Address: Mill Barn, 27 Clay Well Huddersfield HD7 4JD

Application number: 2021/93621	
What is the application for?:	Erection of 10 dwellings and associated works (Within a Conservation Area)
Address of the site or building:	Land off, Fullwood Drive, Golcar, Huddersfield, HD7 4JH
Postcode:

Description: PROPOSED SITE PLAN & 3D VIEW

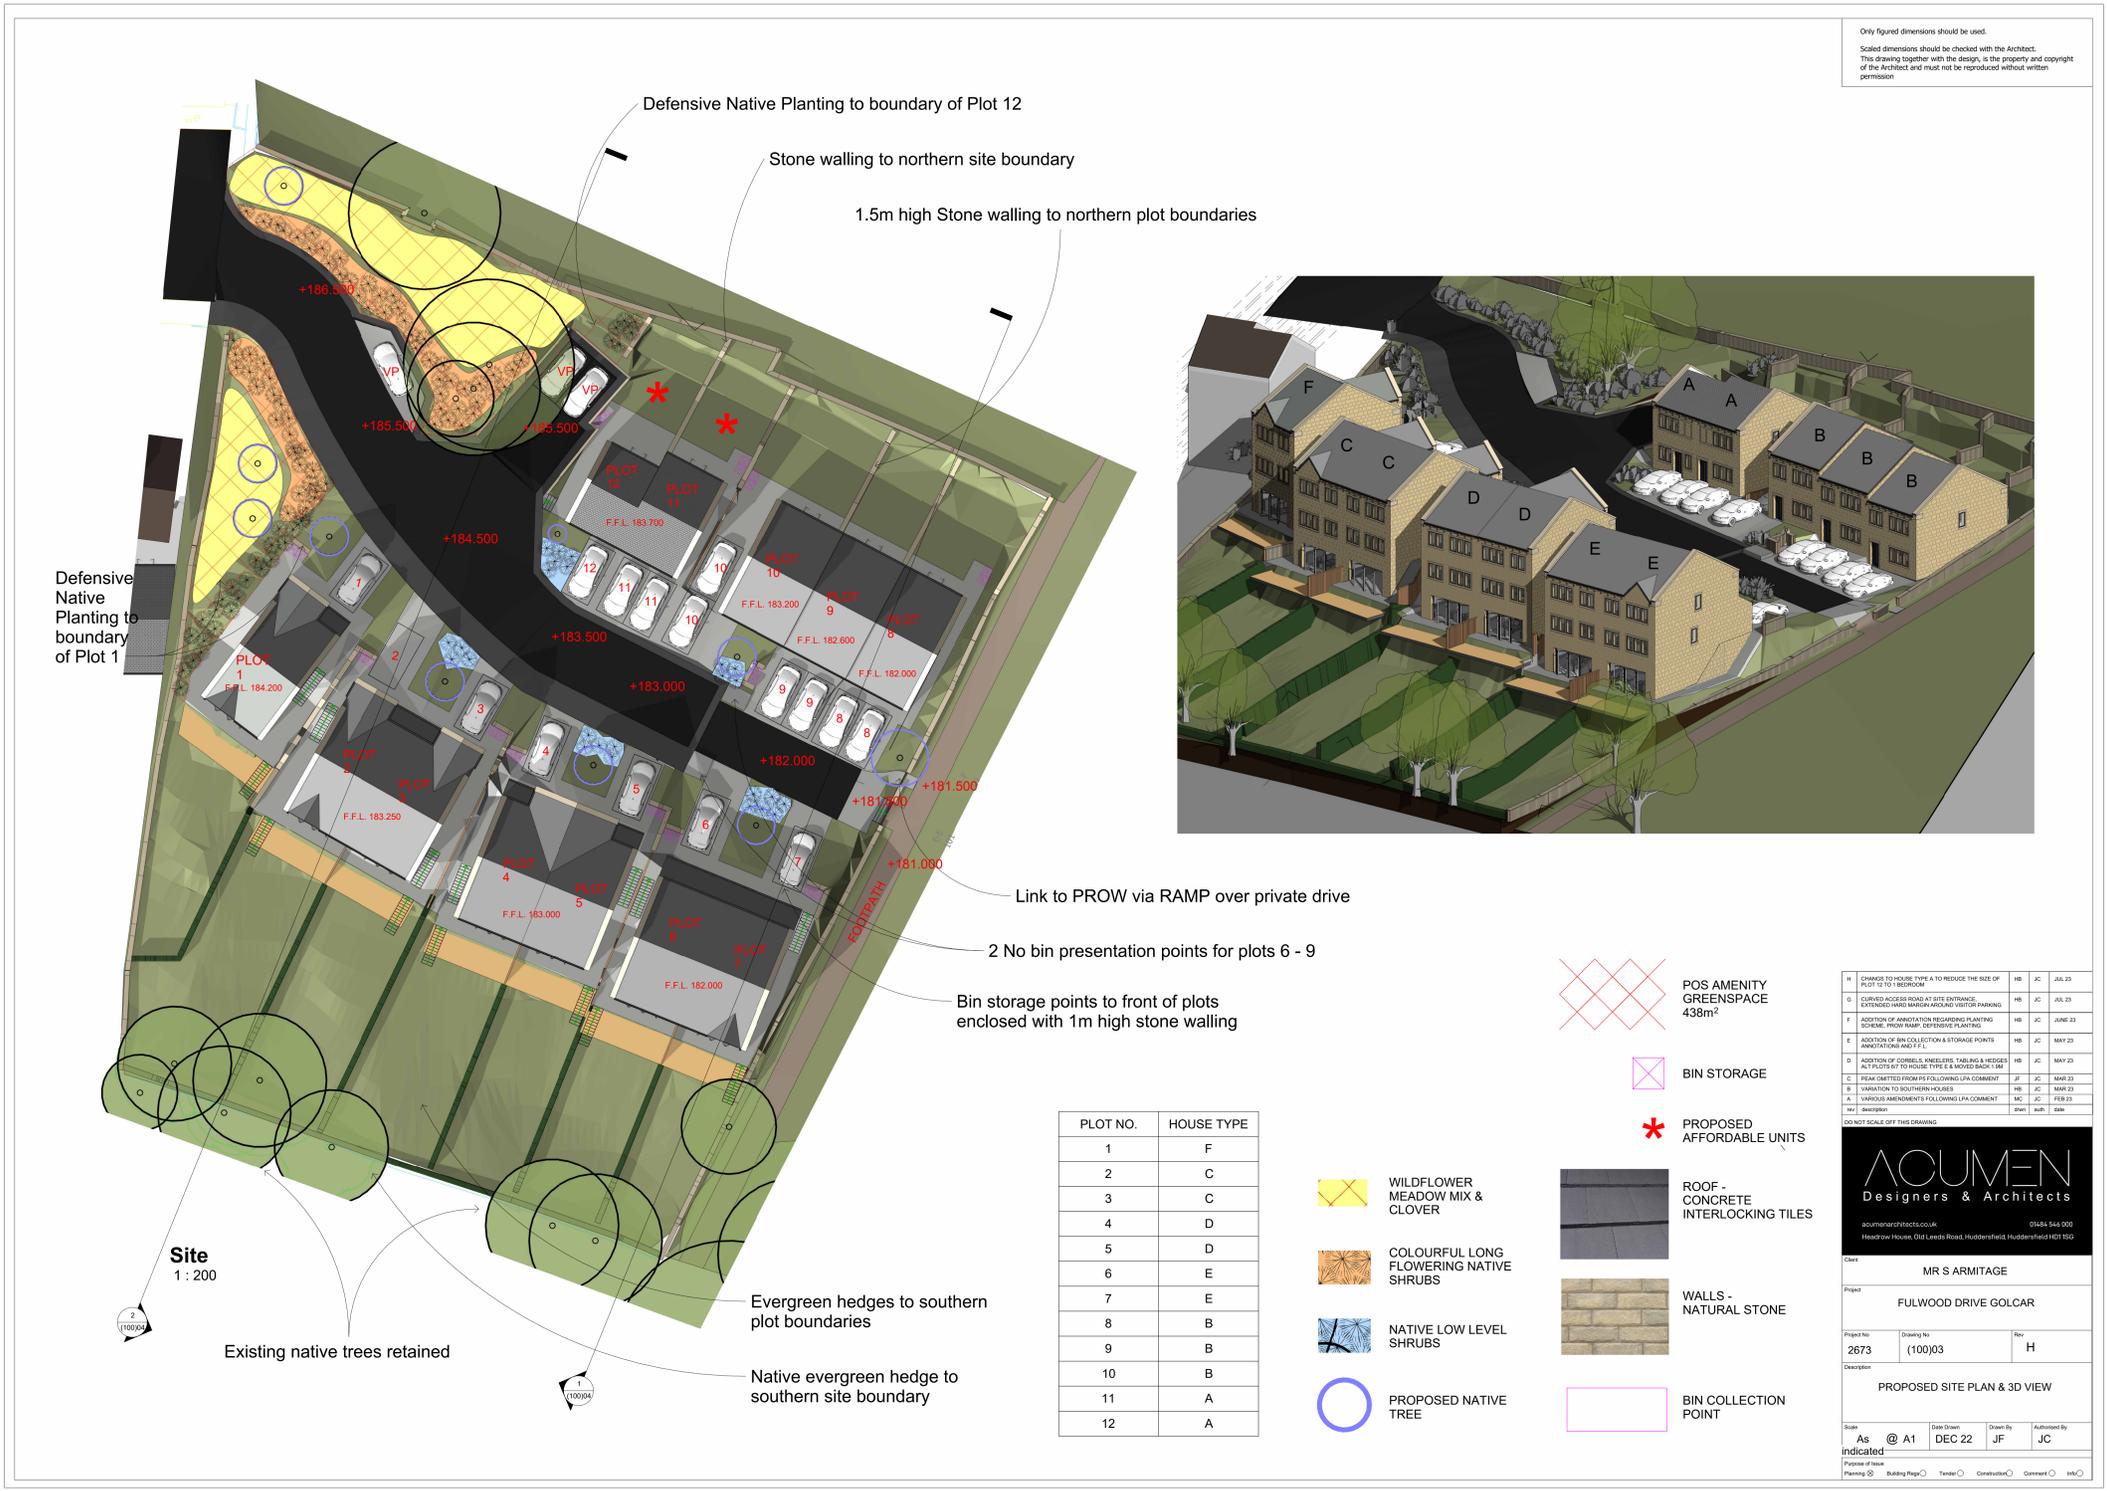
A much better alternative would be to access the plot through the 2 developments (1 currently built & indeed the current application for the second site would seem to indicate that access could continue along the existing footpath and therefore into the proposed development – if this wasn't to be the case surely the plan for the new footpath it would ironically ensure the footpath would be safer as it would require remaking and hence a new footpath.  
[https://mapping.kirklees.gov.uk/connect/analyst/mobile/#/main?mapcfg=Planning%20Applications%20\(Public\)&queryTable=%2Fkirklees%2FPlanning%2FPlanApp](https://mapping.kirklees.gov.uk/connect/analyst/mobile/#/main?mapcfg=Planning%20Applications%20(Public)&queryTable=%2Fkirklees%2FPlanning%2FPlanApp)
